S.21/0072/FUL

Proposal: Proposed single storey extension to provide new entrance lobby together with associated external ventilation plant and alterations to windows

On Behalf Of: Environmental Health (E)

description
PROPOSED ELEVATIONS

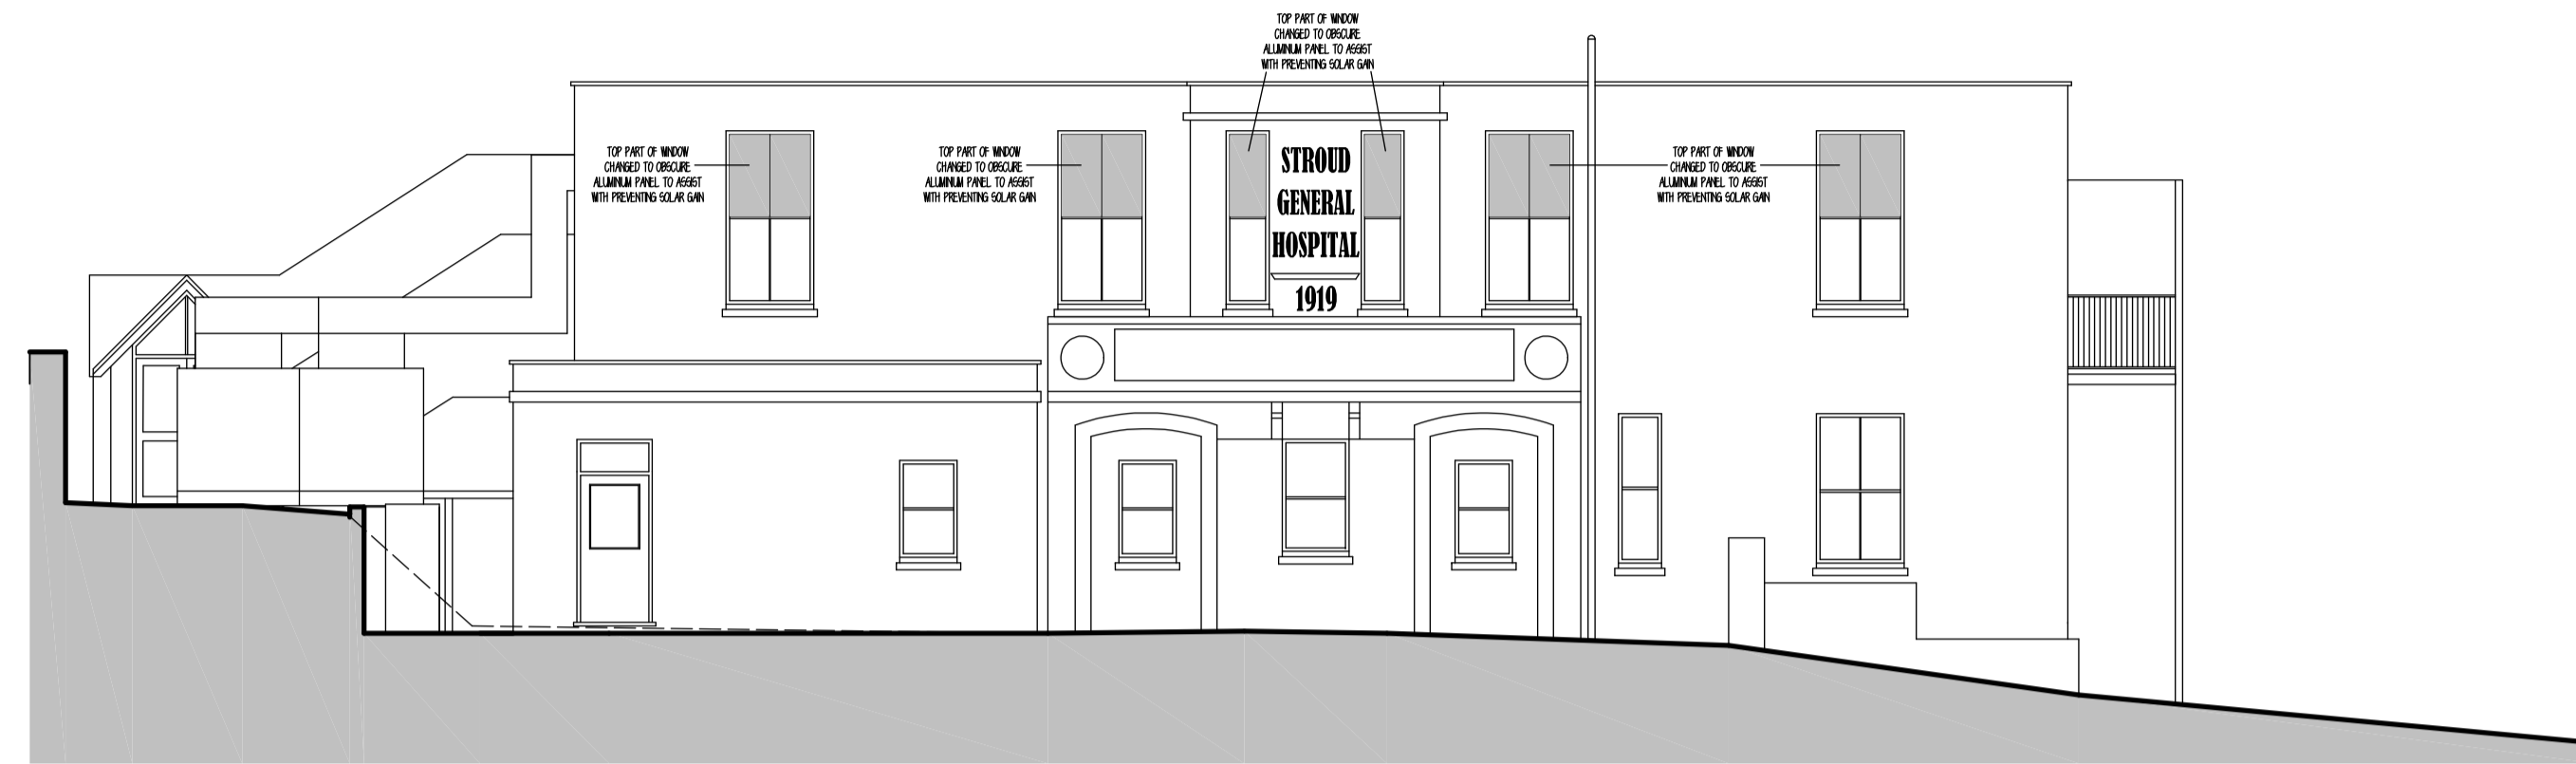
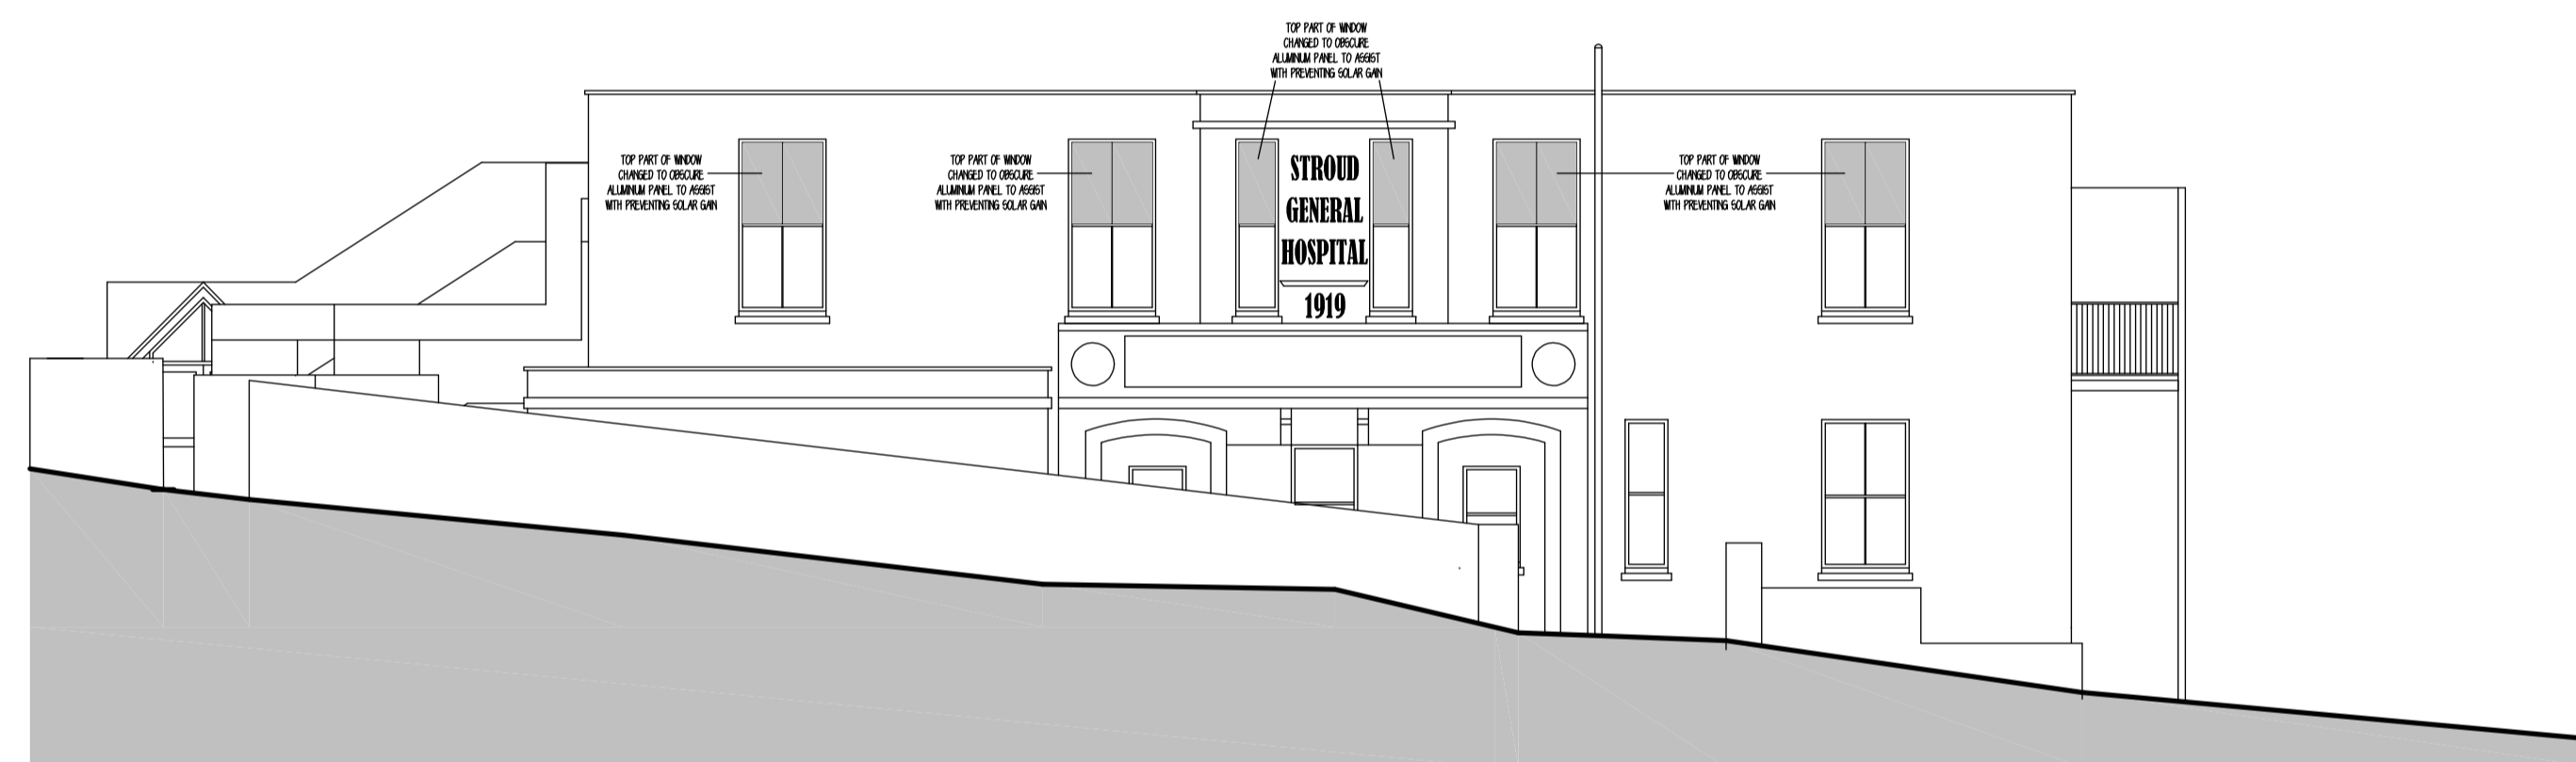
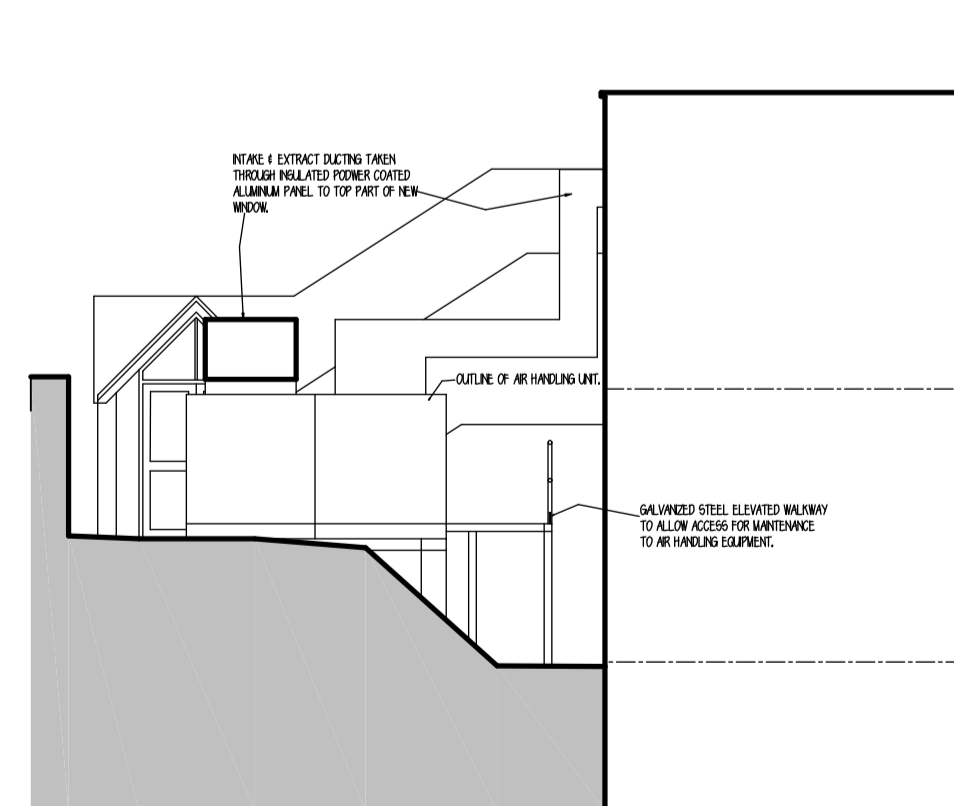
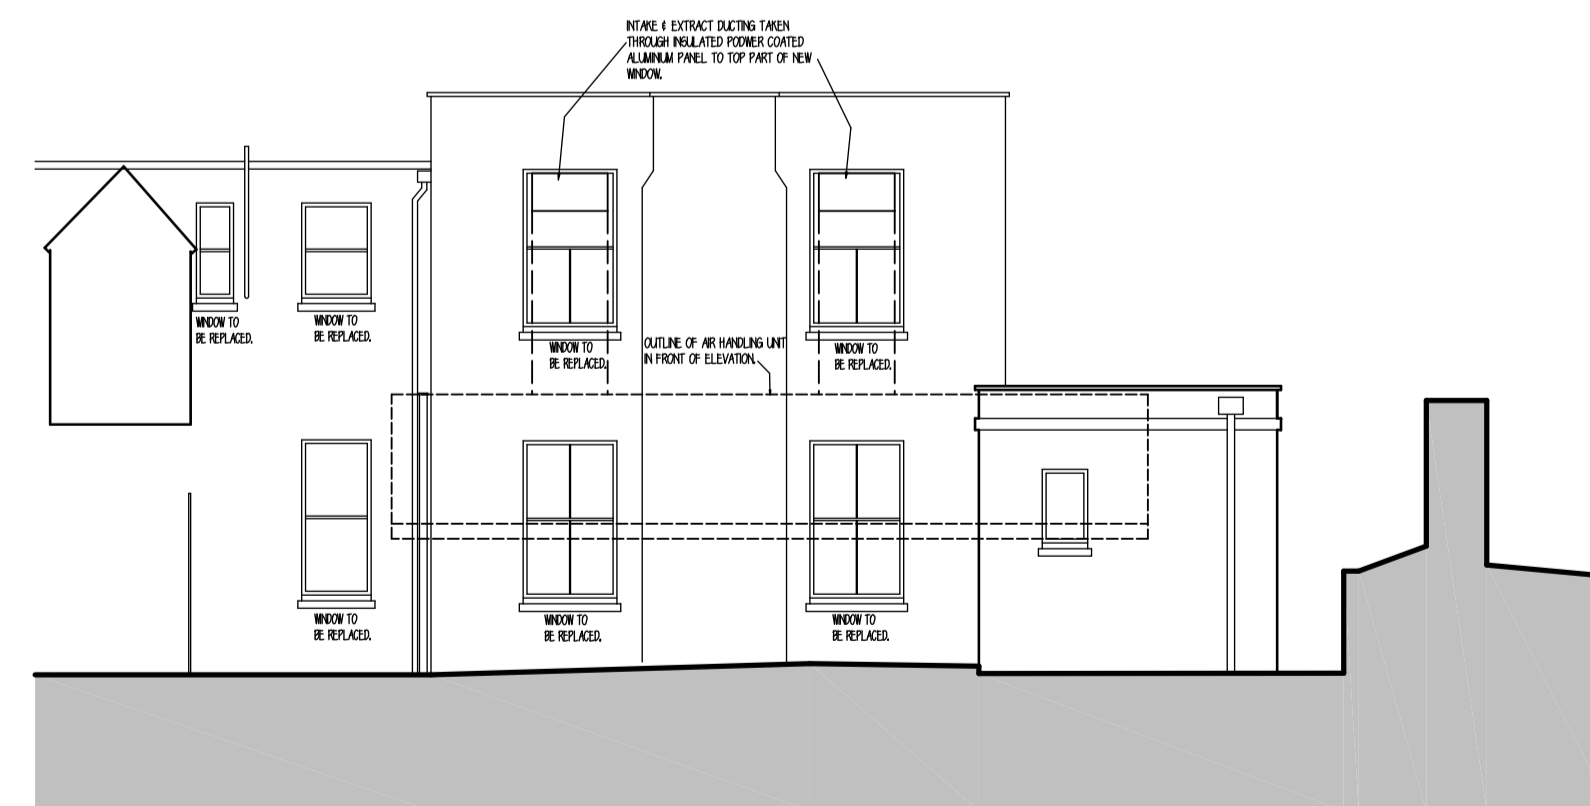
With respect to this application, I would please request additional information in respect of the noise arising from the operation of the proposed air handling units and ventilation plant in terms of the sound levels likely to be experienced at the nearest dwellings, some of which lie as close as 20 metres away.
